A57 LINK ROADS

TR010034

CPRE Peak District and South Yorkshire Branch

CPRE PDSY DEADLINE 4 SUBMISSION – RESPONSE TO ISSUE SPECIFIC HEARING 2

**A57 Link Roads  
TR010034**

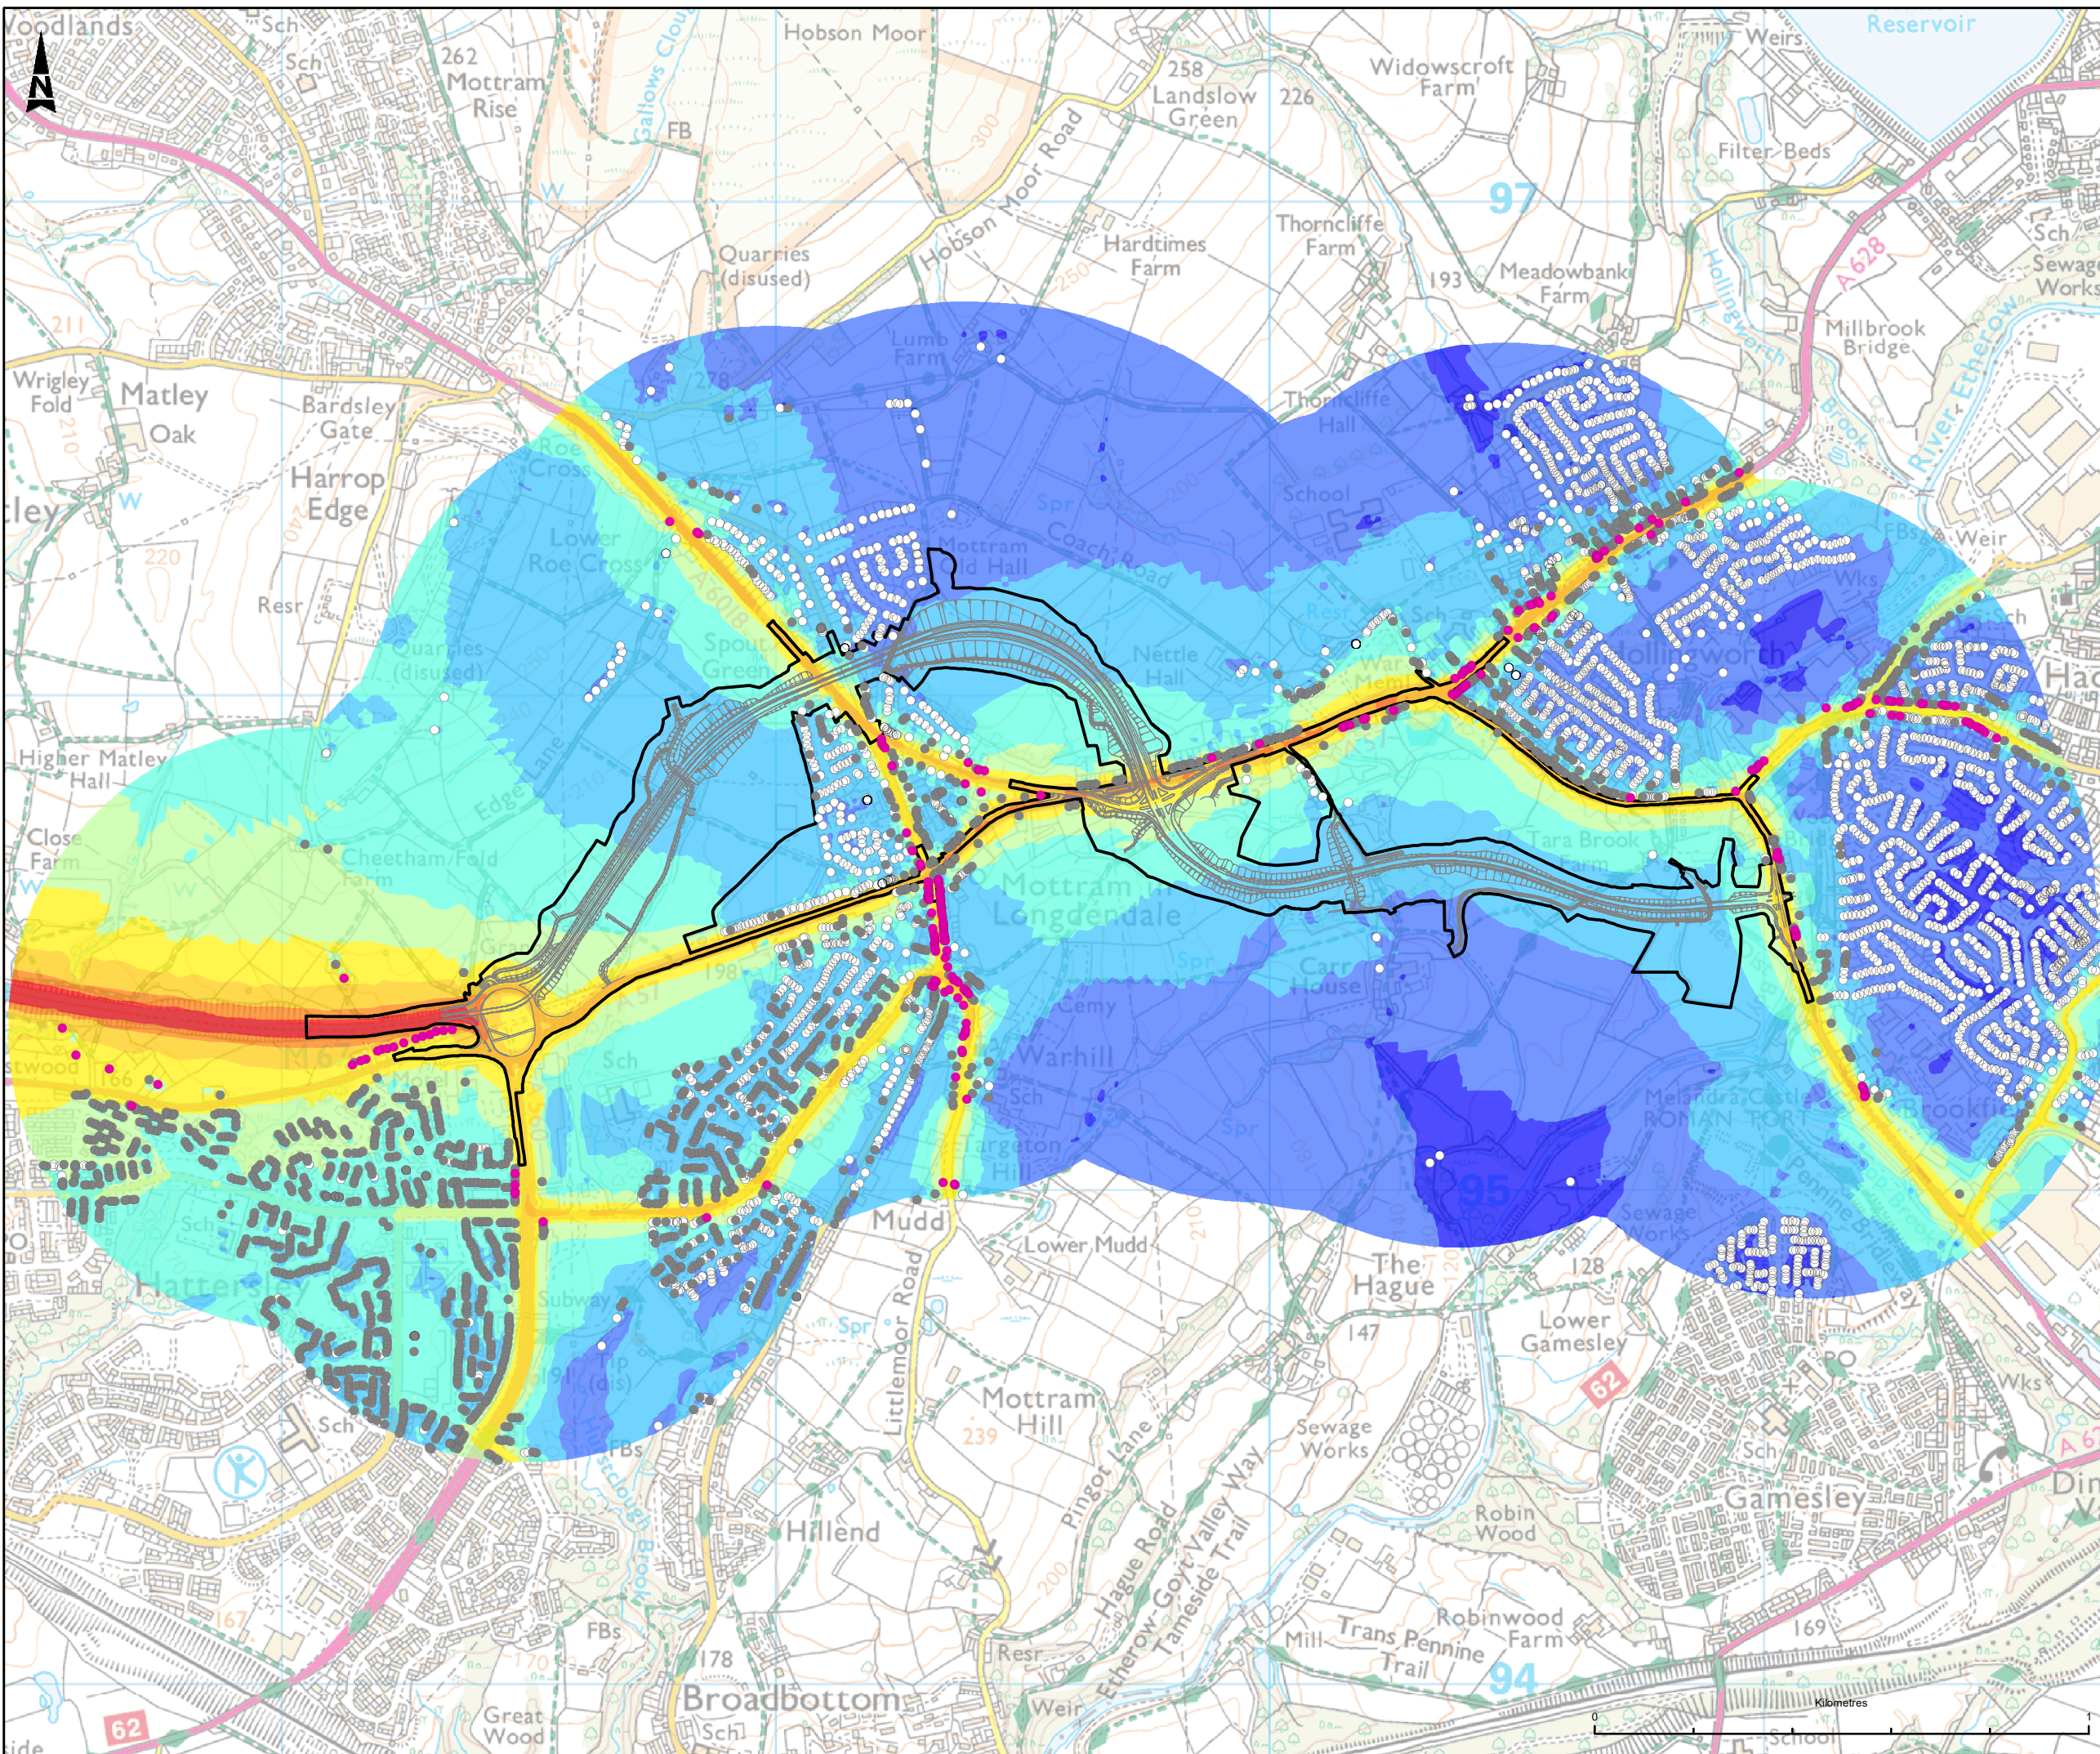
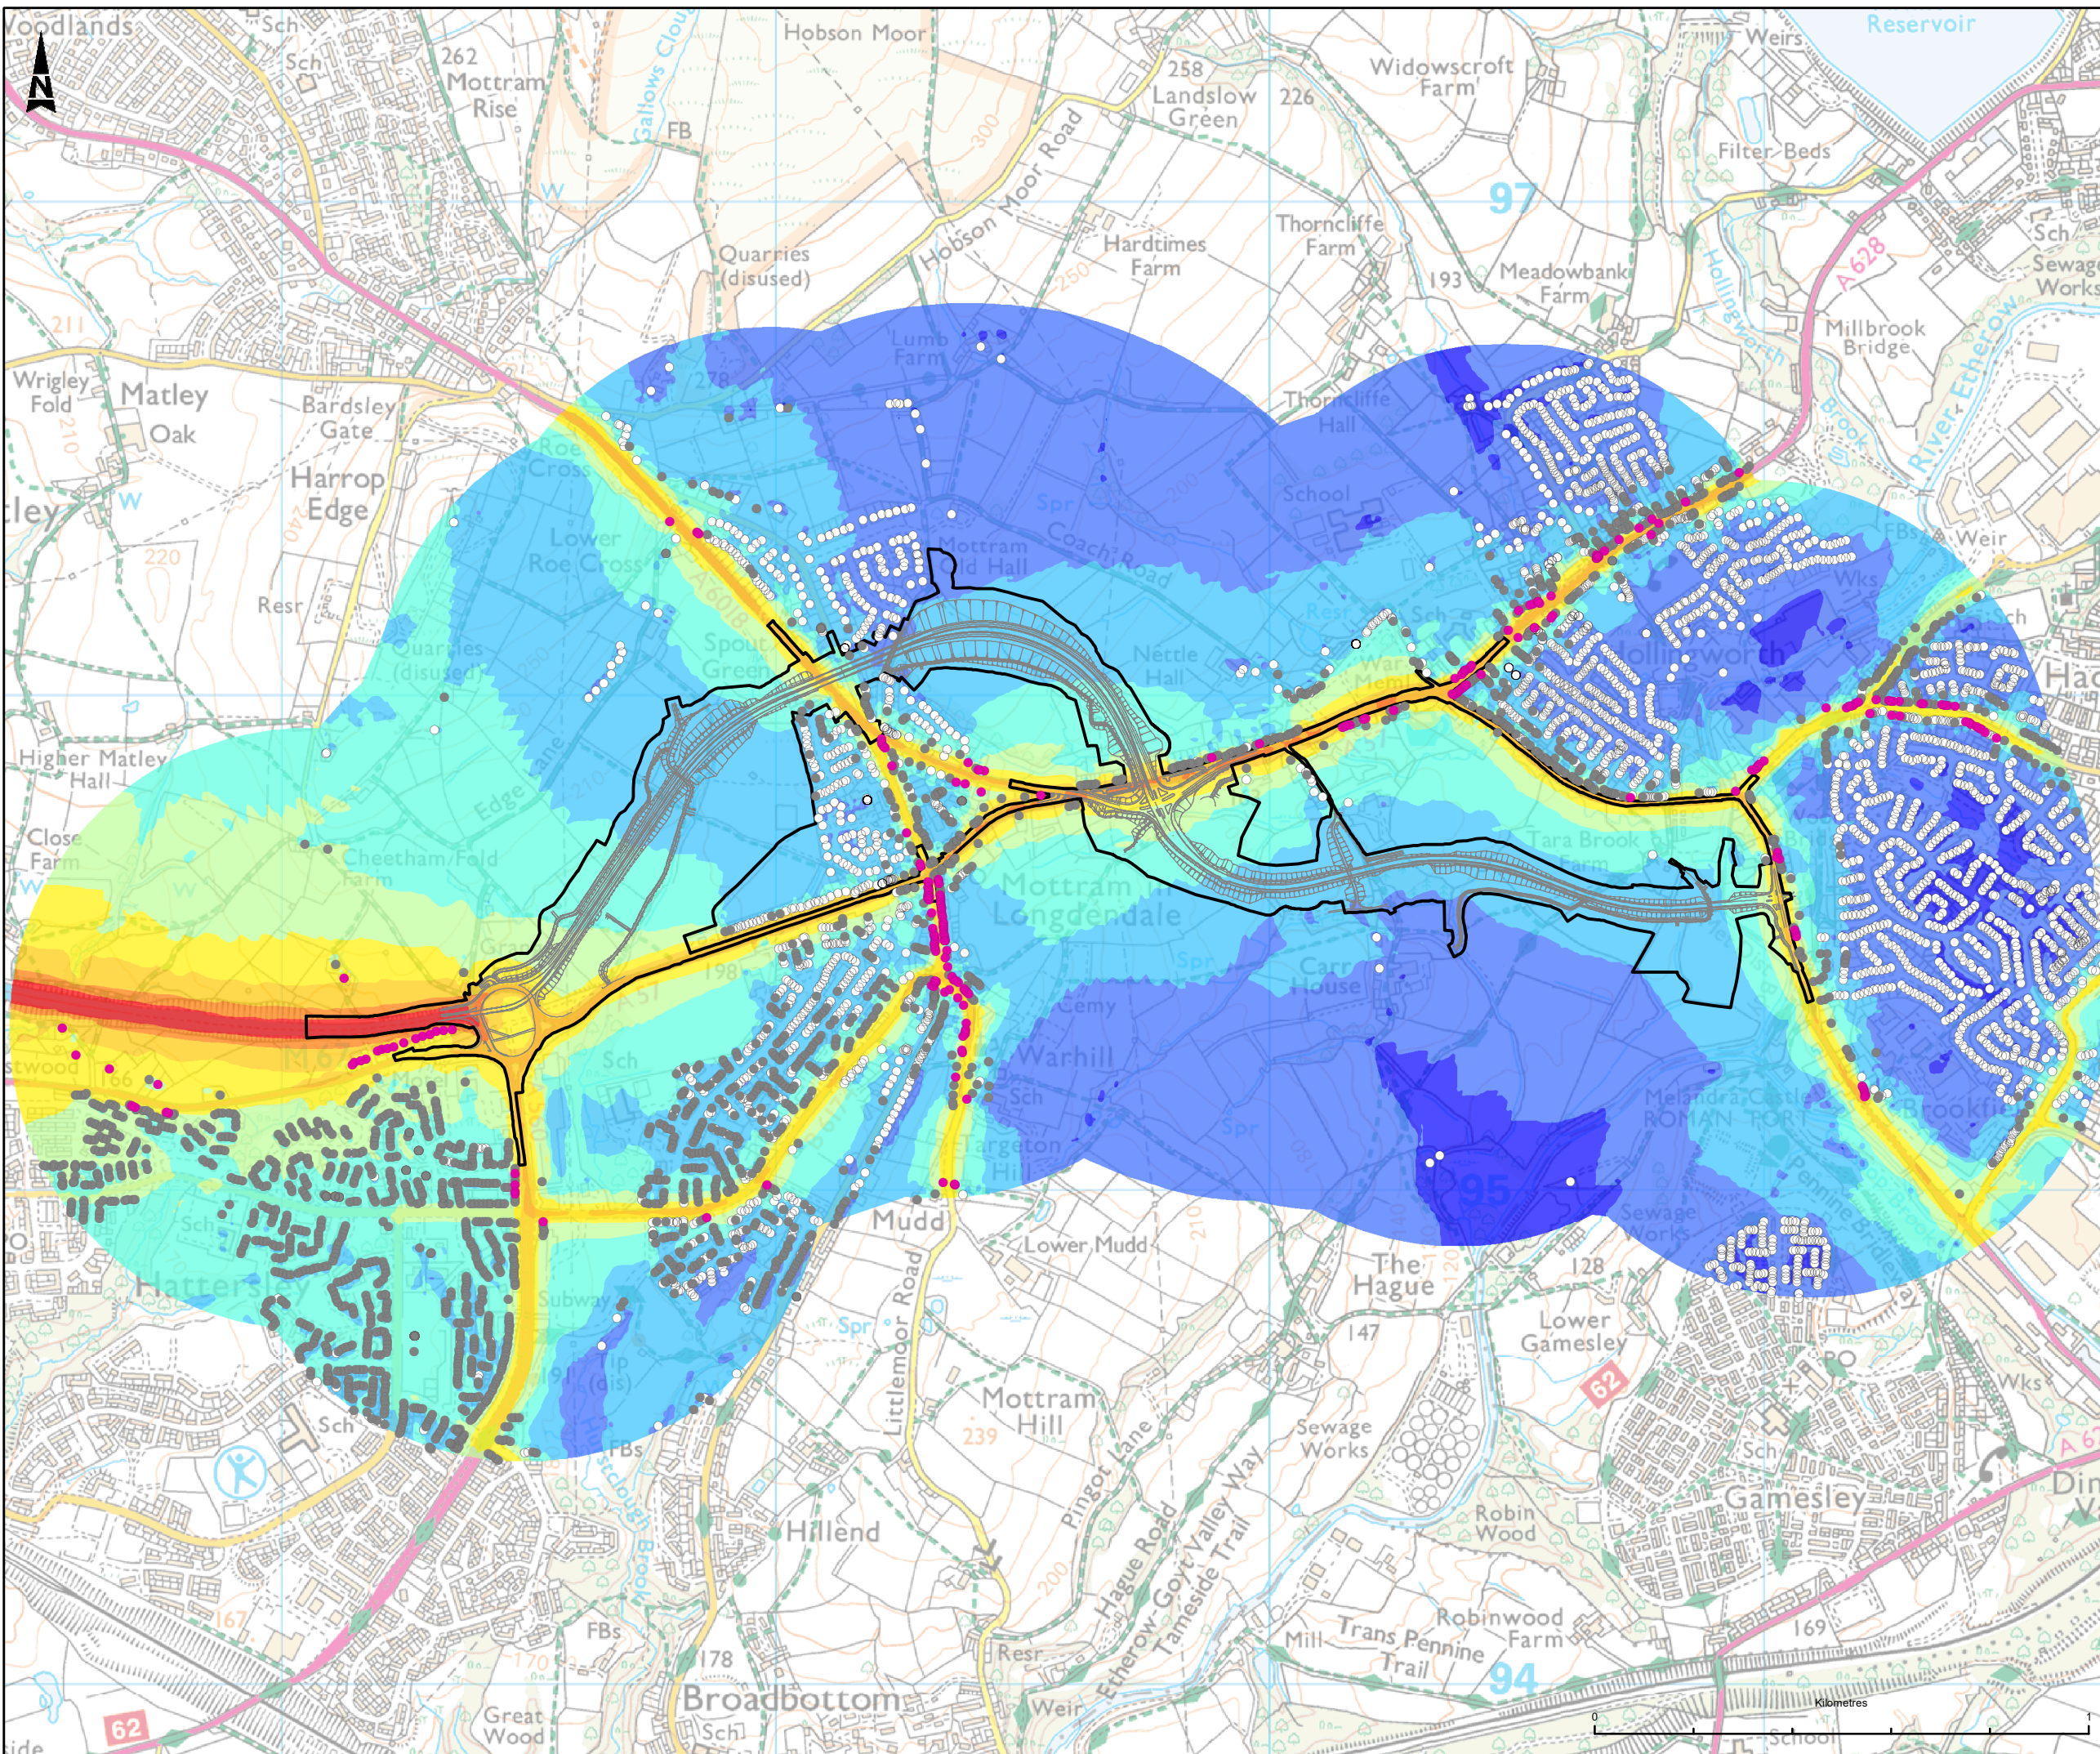
Using the single element noise to measure the impacts of the scheme on National Park's landscapes fails to capture the full effects of the increased traffic. Noise is only one element of tranquillity, which is a multi-layered quality of the countryside and part of the natural beauty of the National Park. Tranquillity is the calm experienced in places with mainly natural features and activities. CPRE's maps reflect both physical qualities and elements and the subjective experience of tranquillity – what is tranquillity, what detracts from it and what enhances it. As the tranquillity map of Derbyshire (page 14) shows the landscape around the A57 Snake Pass is one of the most tranquil in the Peak District. It is a natural landscape, wide open blanket bog and heather moorland, with birds such as curlew and golden plover but above all where silence peace and quiet can be found. The landscape around the A628 is less tranquil but the aesthetic and perceptual qualities are strong in the landscapes adjacent to both roads - solitude, inspiration and awe at the astonishing beauty, threat from the terrain or weather. The top detractor from tranquillity according to the

CPRE assessment is hearing constant noise from cars, lorries and motorbikes. Traffic was strongly verified as being something not seen in a tranquil place, and car noise as something

not heard in a tranquil place. If National Park purposes are to be met and tranquillity enhanced then traffic along both routes should be reduced, not increased.
